**KIRKLEES METROPOLITAN COUNCIL
INVESTMENT & REGENERATION SERVICE**

**DELEGATED DECISION TO DETERMINE APPLICATIONS FOR
CONSENT, AGREEMENT OR APPROVAL REQUIRED BY CONDITION**

Reference No:	2026/44/91306/W
Site Address:	Lumb Lane Nurseries, Lumb Lane, Almondbury, Huddersfield, HD4 6SZ
Description:	Discharge of details reserved by conditions 3 (materials), 4 (windows and doors details), 6 (boundary treatment scheme), 7 (landscaping) and 13 (lighting scheme) on previous permission 2025/92440 for erection of four dwellings
Recommending Officer:	Danielle Cooper

Officer Report

Flush Casement Window

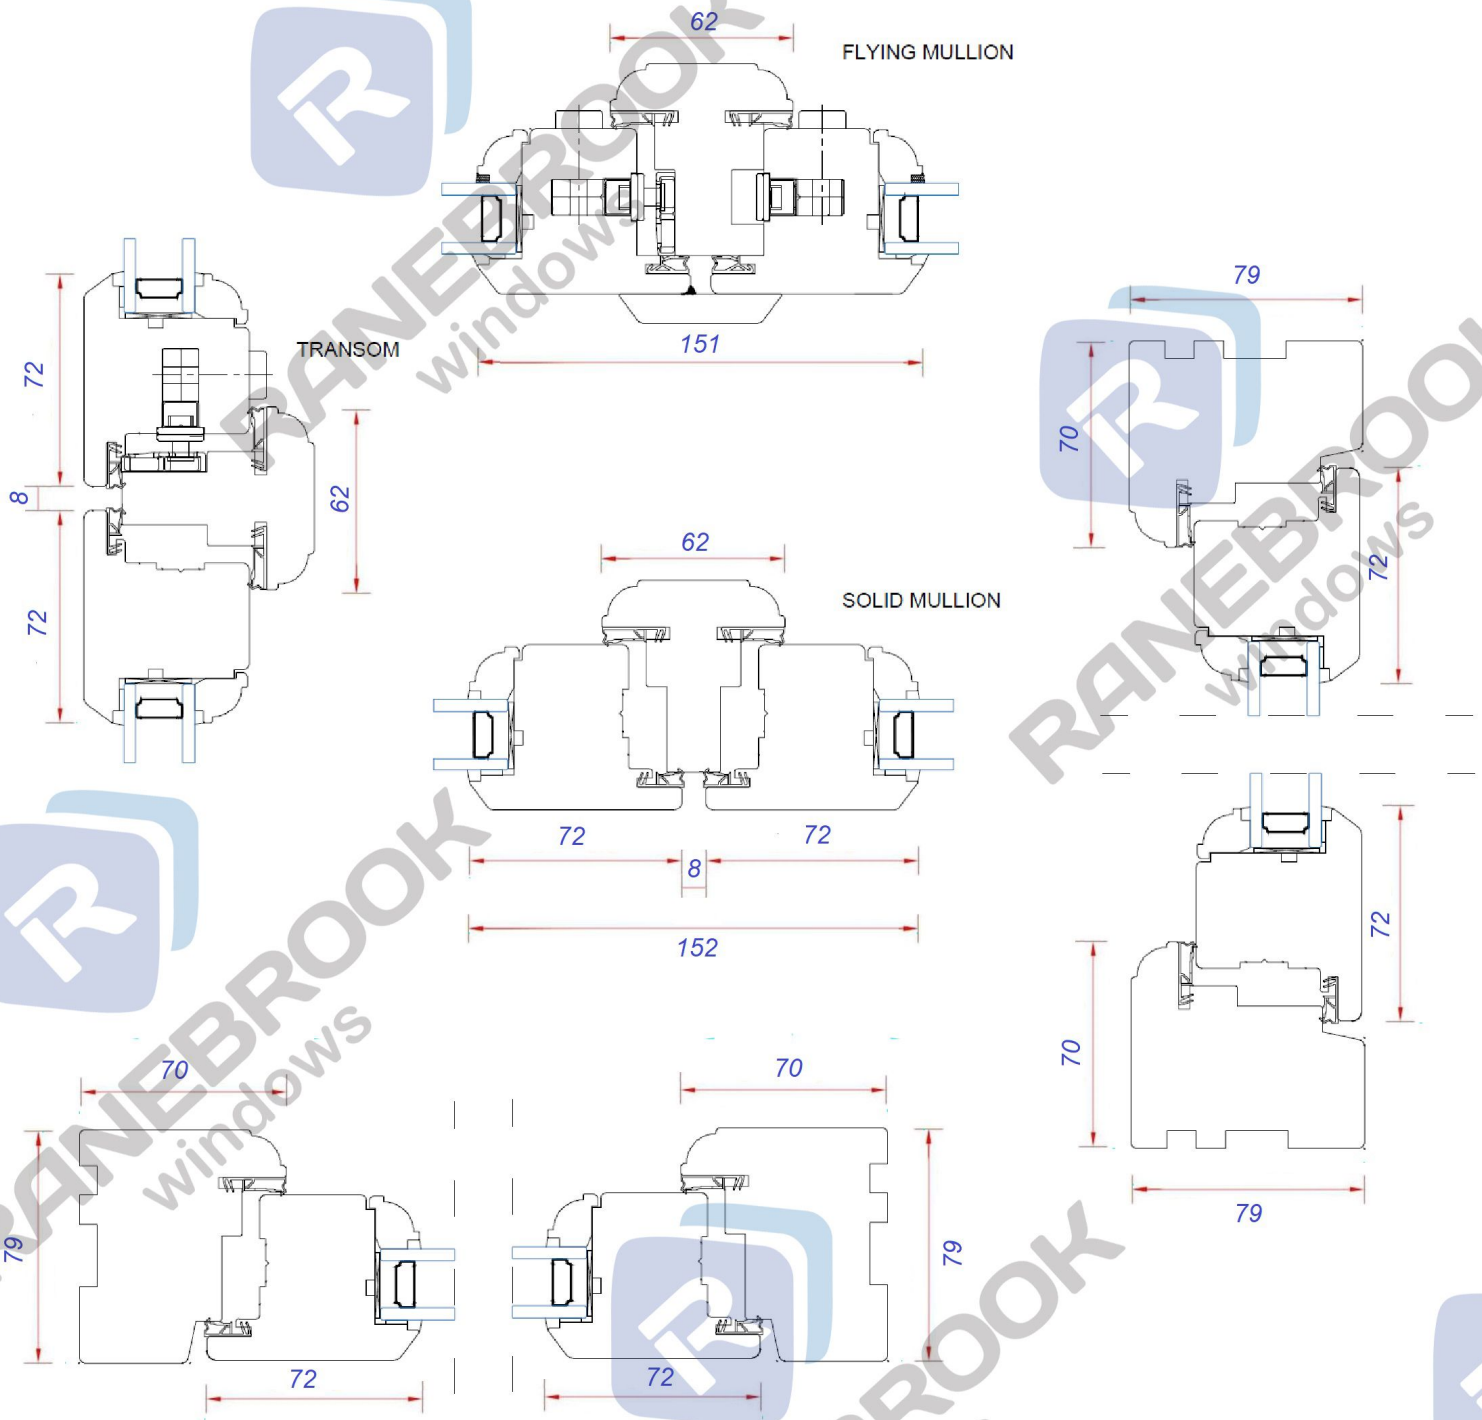
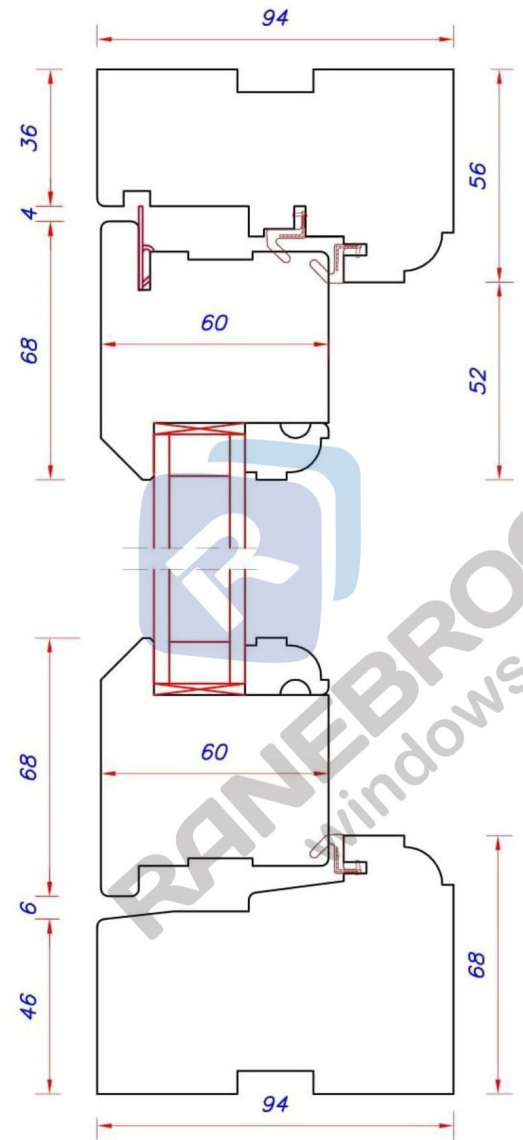
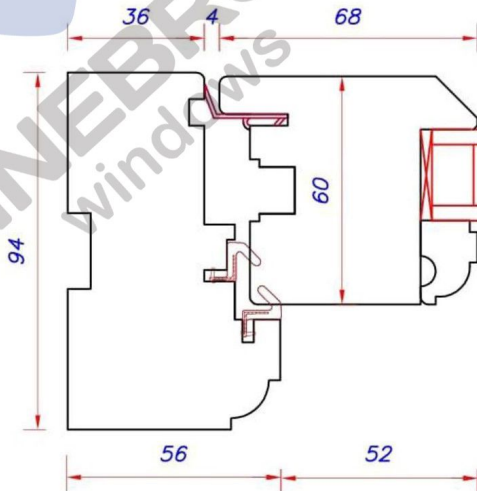
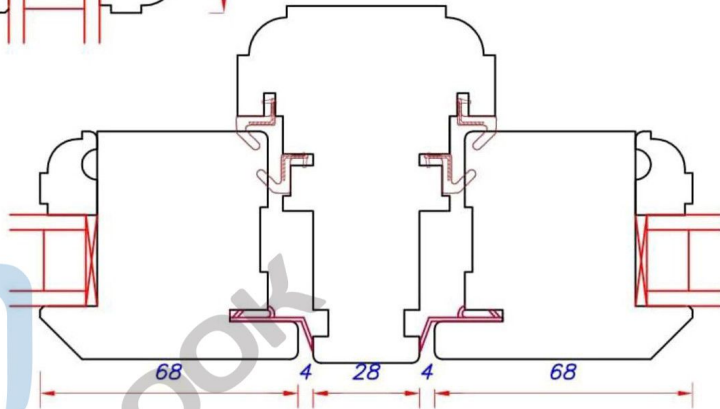
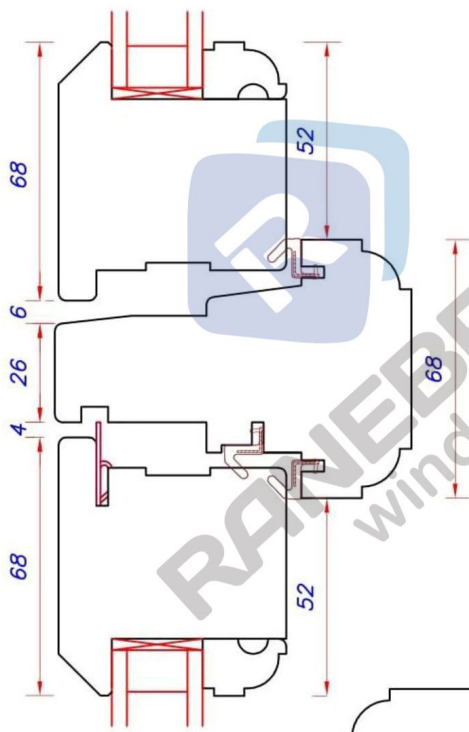
KC Conservation and Design were consulted and confirmed that they accept the details of the proposed windows to be timber flush casement double glazed windows with windows recessed 150mm into openings. Condition 4 can therefore be discharged. The details are acceptable for the discharge of condition 4 of previous permission 2025/92440. The scheme shall be implemented in accordance with the approved details and retained in perpetuity.
